**EL PASO COUNTY PLANNING AND
 COMMUNITY DEVELOPMENT
 DEPARTMENT**

STORMWATER MANAGEMENT PLAN CHECKLIST

PPR219

GRADING & EROSION CONTROL PLAN
CLAREMONT BUSINESS PARK 2 FIL. NO. 1 - LOT 4
JOB NO. 44-037
DATE PREPARED: FEBRUARY 15, 2021
DATE REVISED: APRIL 21, 2021

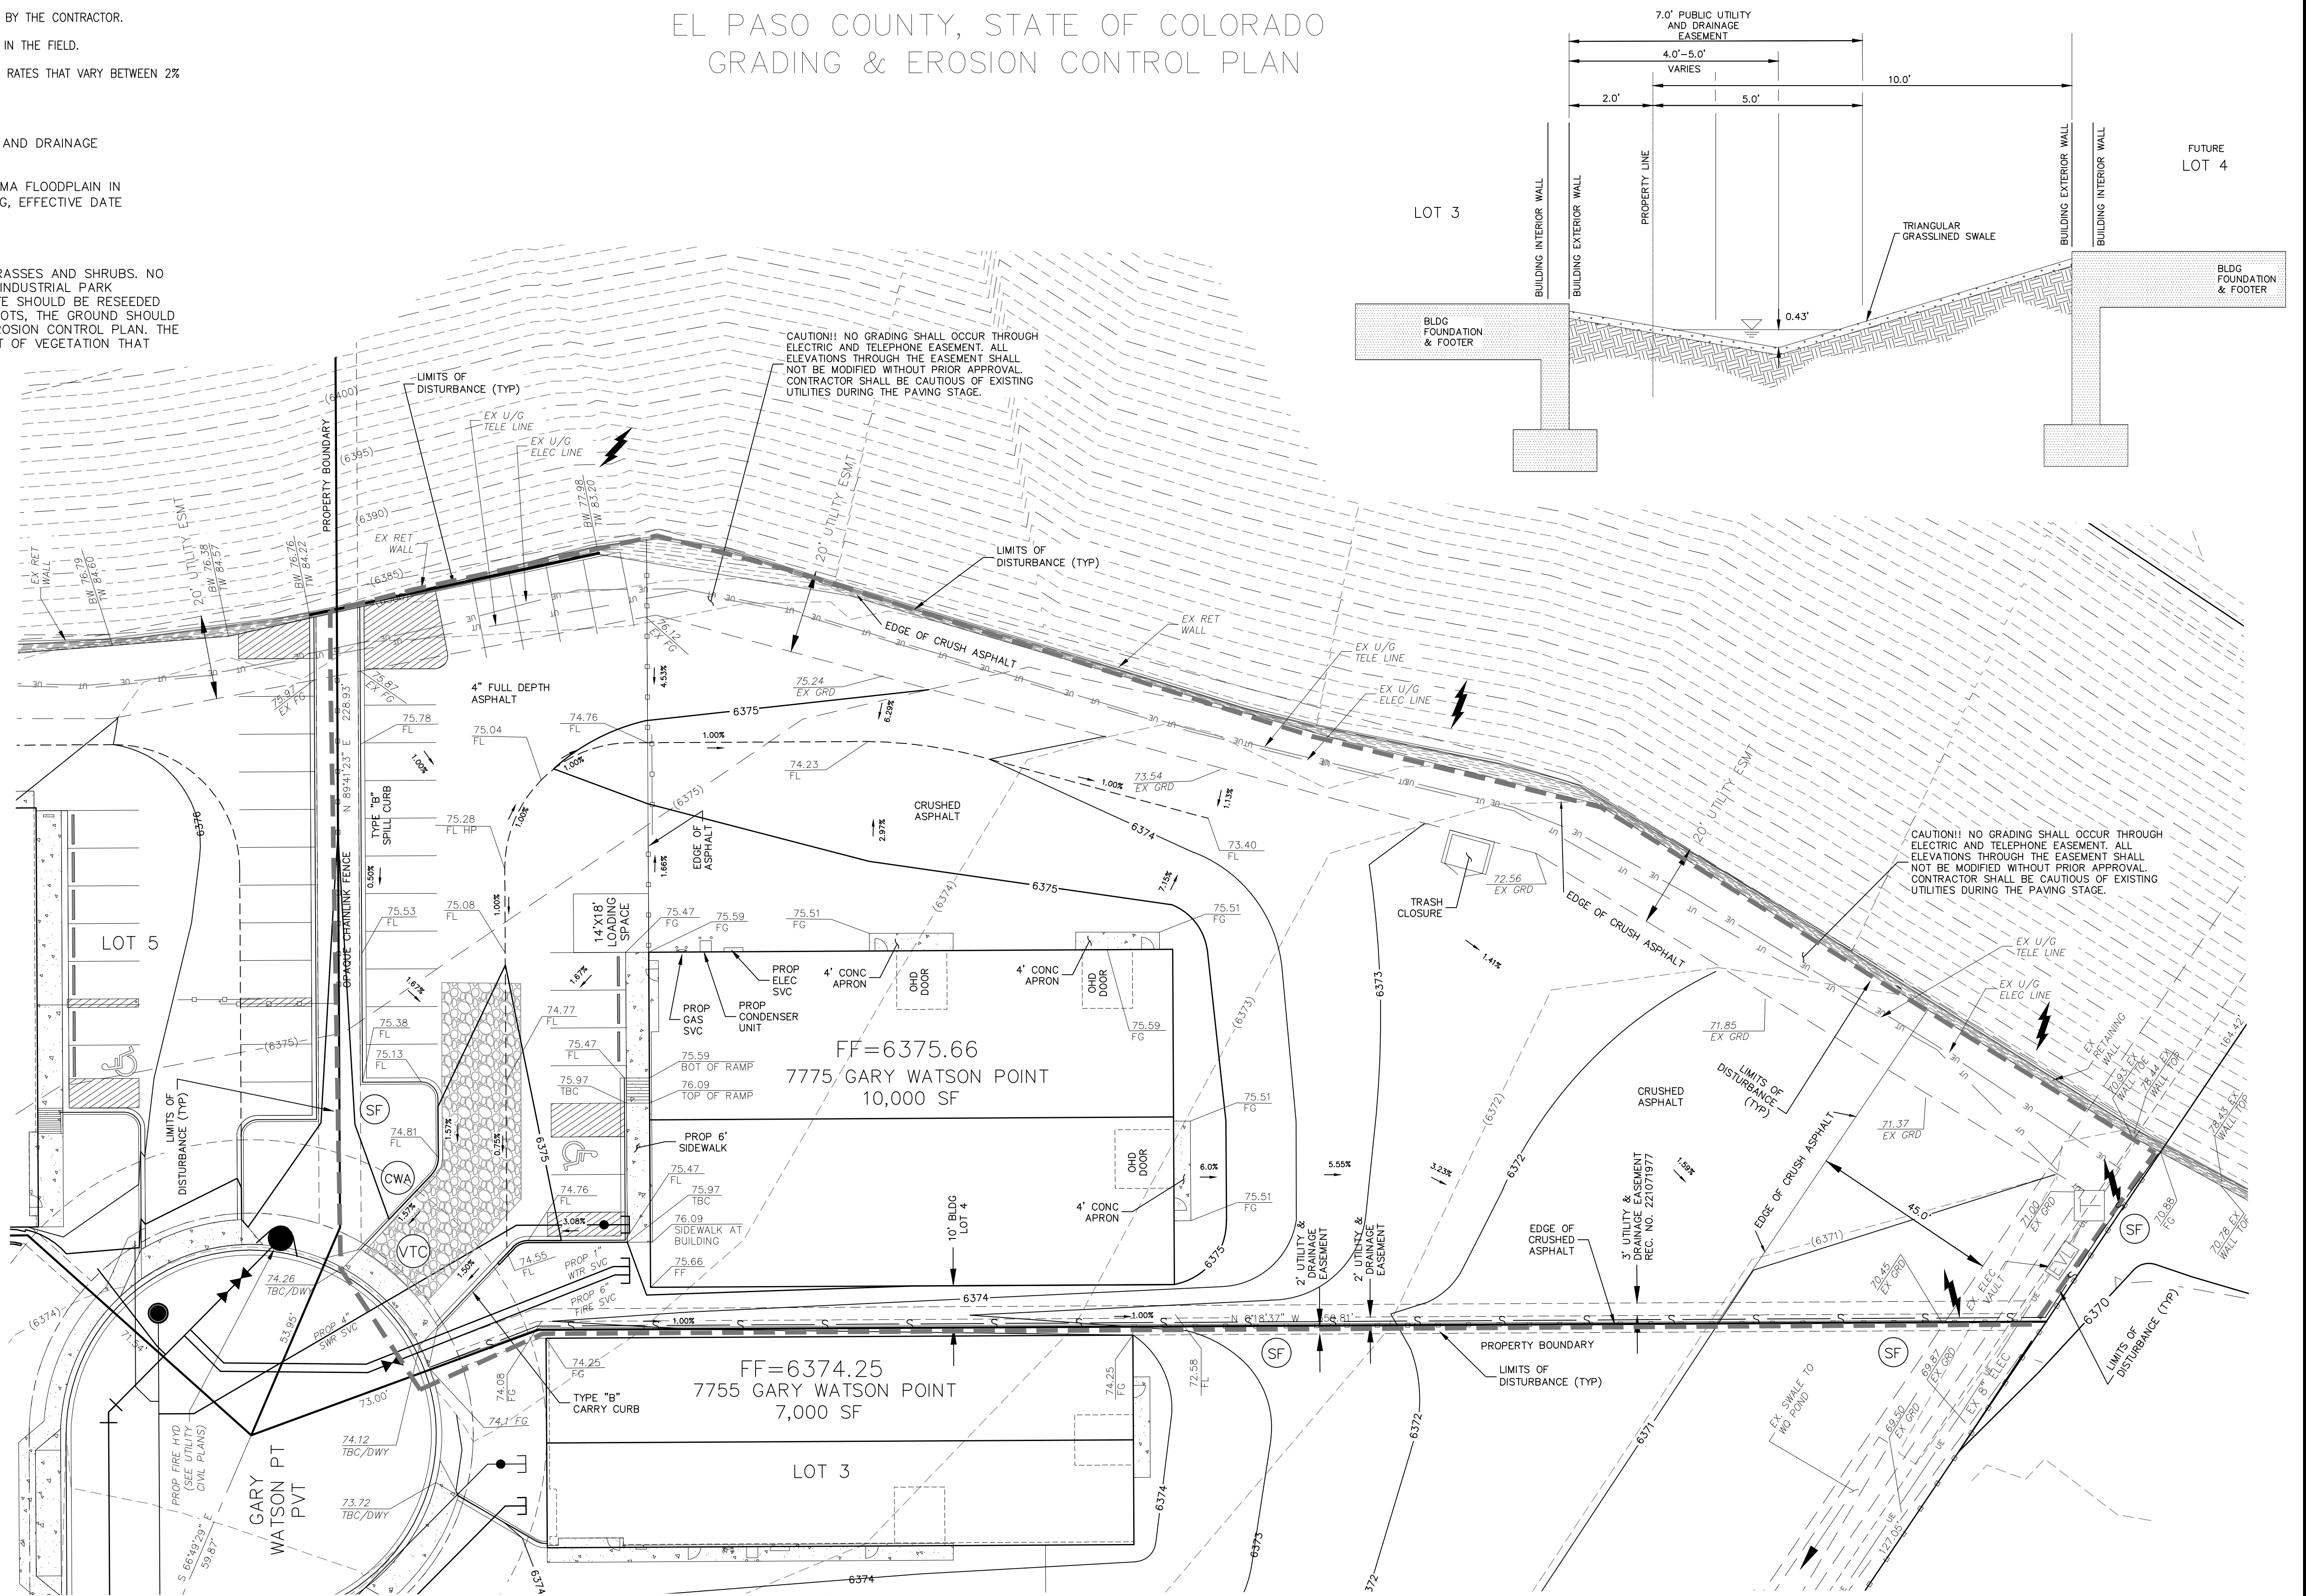
Revised: July 2019		Applicant	PCD
17	SWMP Map to include:	X	
17a	construction site boundaries	X	X
17b	flow arrows to depict stormwater flow directions	X	✓
17c	all areas of disturbance	X	✓
17d	areas of cut and fill		X
17e	areas used for storage of building materials, soils (stockpiles) or wastes	X	✓
17f	location of any dedicated asphalt / concrete batch plants	N/A	X
17g	location of all structural control measures	X	X
17h	location of all non-structural control measures	X	X
17i	springs, streams, wetlands and other surface waters, including areas that require maintenance of pre-existing vegetation within 50 feet of a receiving water	X	X
18	Narrative description of all structural control measures to be used. Modifications to EPC standard control measures must meet or exceed County-approved details.	X	✓
19	Description of all non-structural control measures to be used including seeding, mulching, protection of existing vegetation, site watering, sod placement, etc.	X	✓
